**From:** Claire Potts  
**Sent:** 13 April 2017 10:35  
**To:** Julia Mills  
**Subject:** FW: AL10716RES - revised plans (email 3)  
**Attachments:** Parking Plan - Rev G.pdf; Material Schedule - Rev K.pdf; Open Space Plan - Rev C.pdf

**From:** Claire Potts [<mailto:Claire.Potts@arun.gov.uk>]  
**Sent:** 12 April 2017 11:10  
**To:** Wright, Aaron [REDACTED]  
**Cc:** Lucy Harding <[Lucy.Harding@arun.gov.uk](mailto:Lucy.Harding@arun.gov.uk)>  
**Subject:** FW: \*Ext: RE: AL10716RES\_DRAFT CONDITIONS+AW

**Sent:** 11 April 2017 17:18**To:** Lucy Harding**Cc:** Claire Potts**Subject:** RE: \*Ext: RE: AL10716RES\_DRAFT CONDITIONS+AW

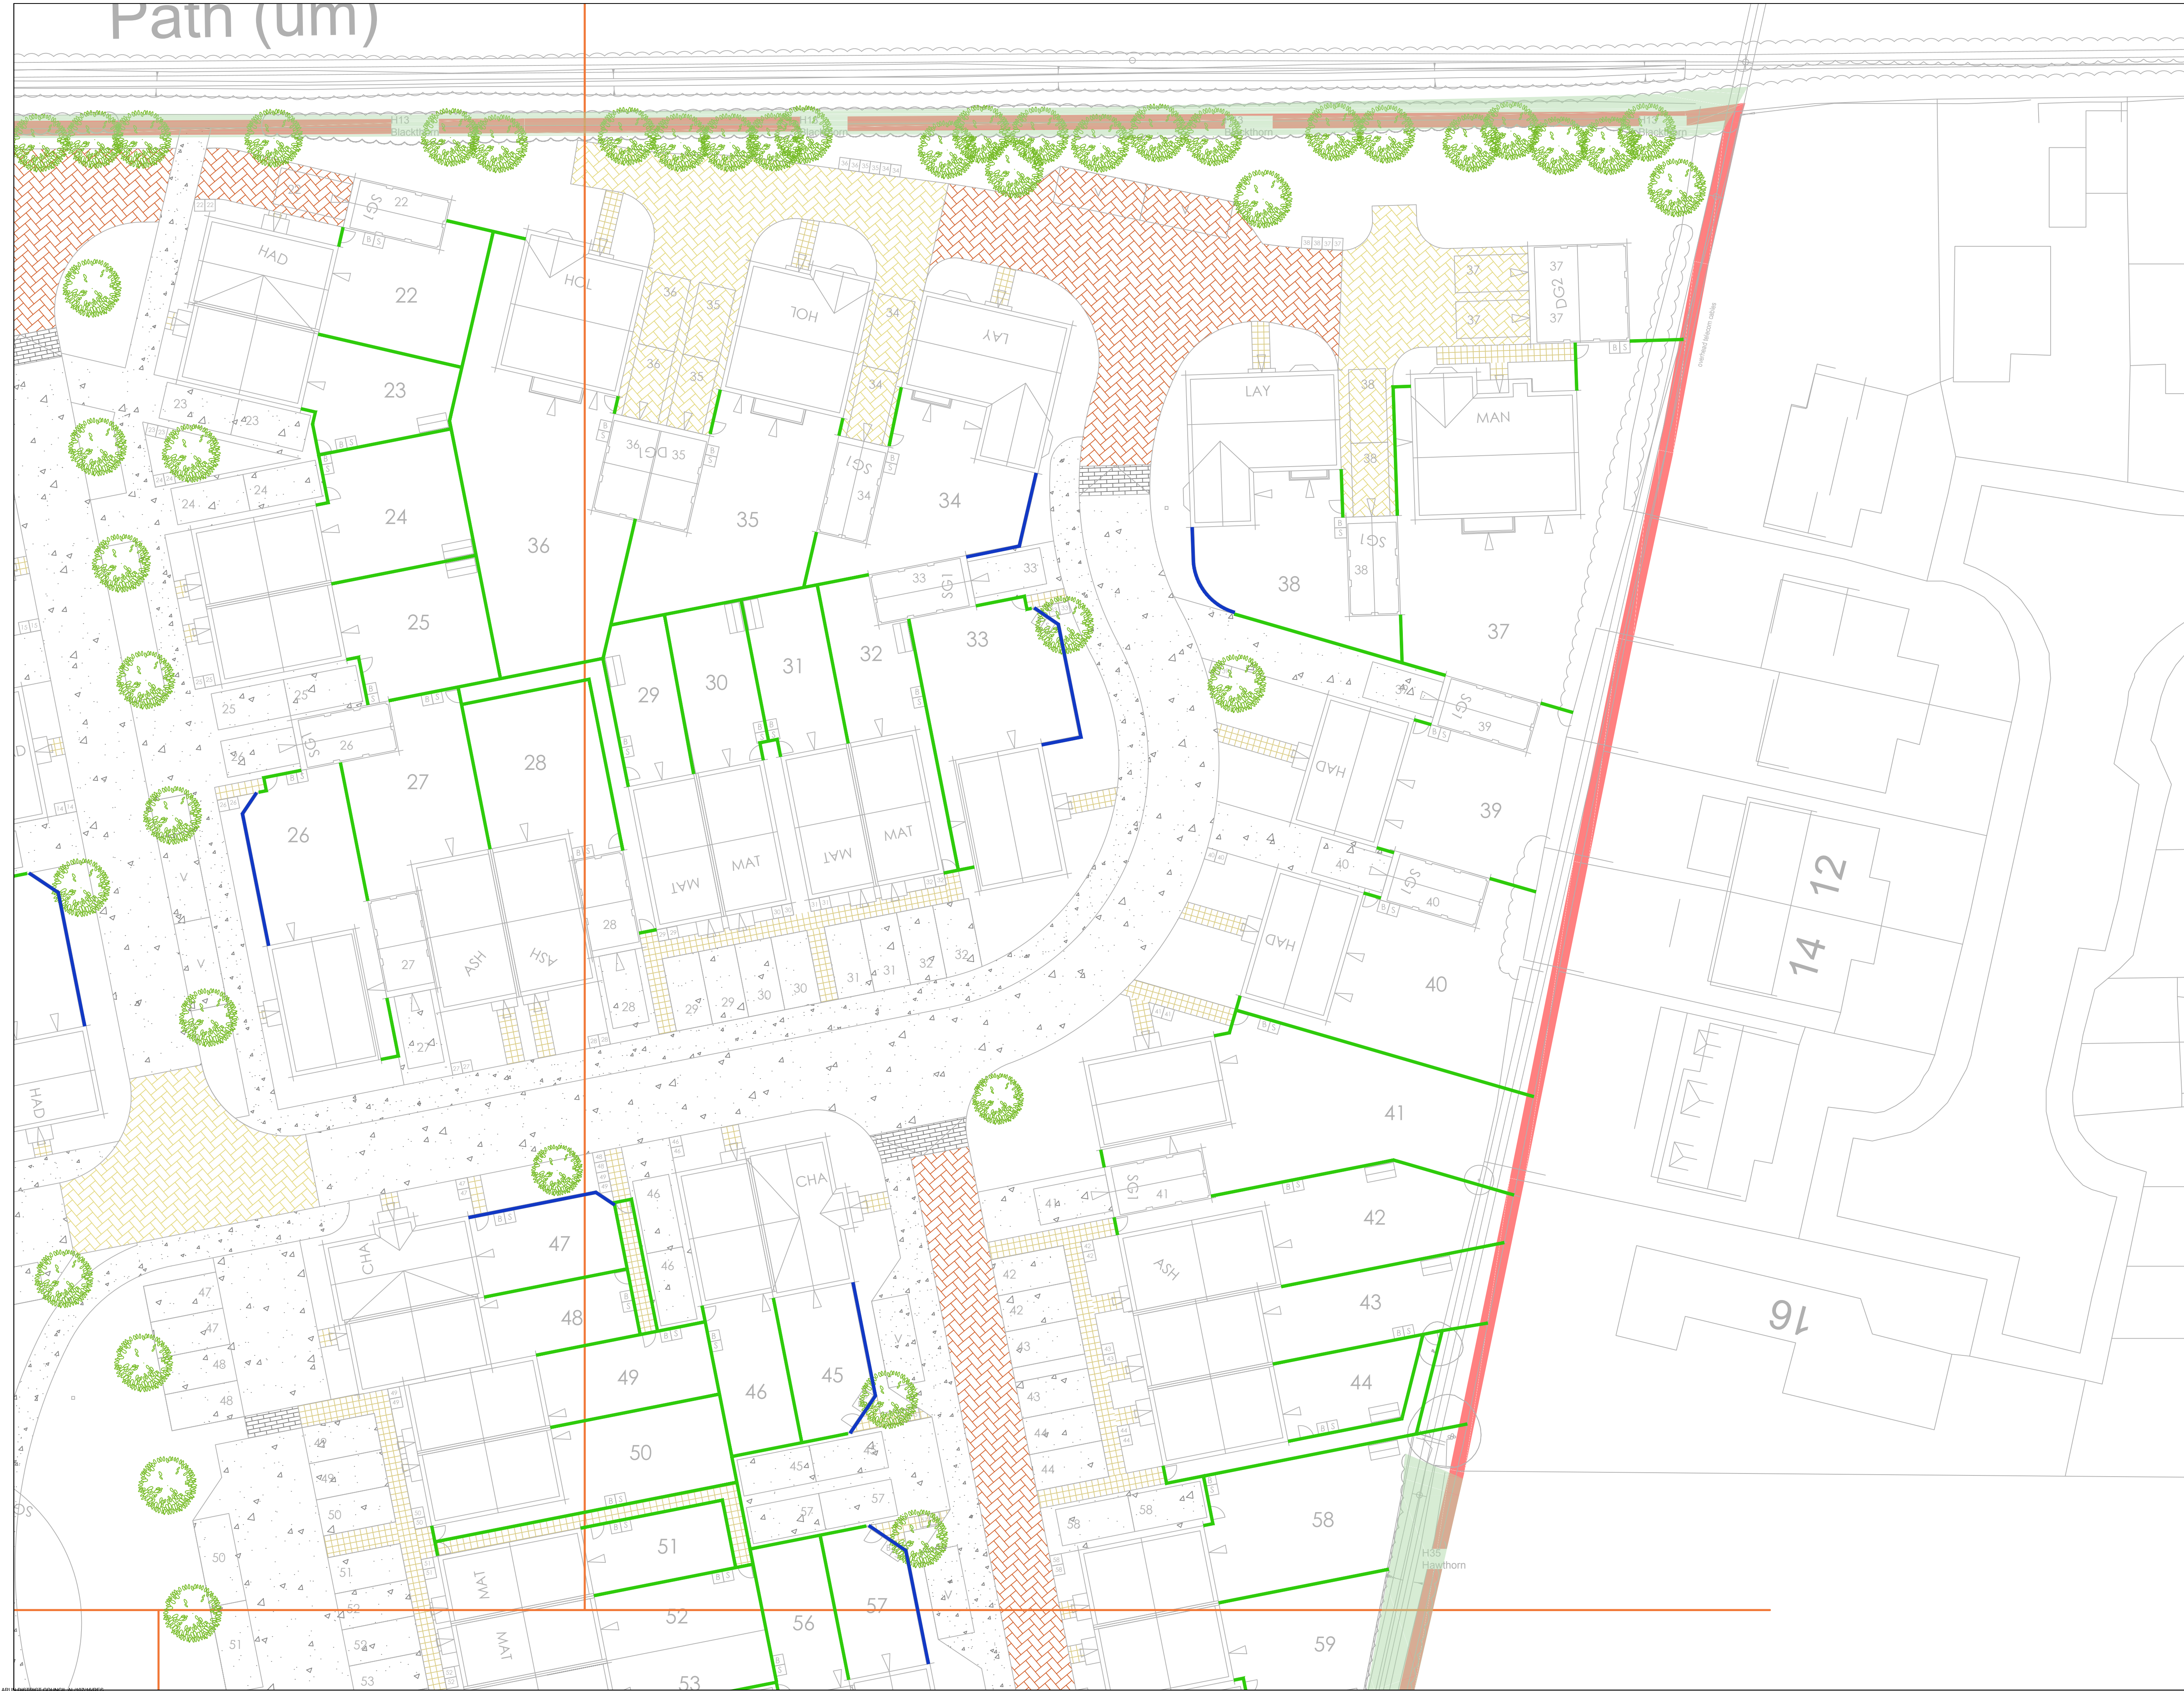
I have had a look at the attached revised plans, which the general landscape arrangement across the drawings is fine. We had however discussed some provision of planting to the periphery of the central balancing pond adjacent to the LEAP, which does not appear to feature on these plans?

There is now a very token of planting to the balancing pond adjacent to the pumping station (7no Salix) but nothing detailed to the central one? Which is where we would have liked to have seen the addition of some groupings of water tolerant planting. Not sure if this is an intended omission or if the developers were given this feedback or not?

In summary the general Landscaping scheme is fine, so too is the addition to provide a 1.2m post and rail fence to the pond edges, we would however recommend the addition of further planting be proposed to both of the balancing pond edges.

Please find attached the revised landscape drawings. The plans show SUDS Wildflower Turf (WFT-SUD-37) as supplied by Wildflower Turf of similar and approved, within the balancing ponds. The ponds are shown to be enclosed by a 1.2m post and rail fence.
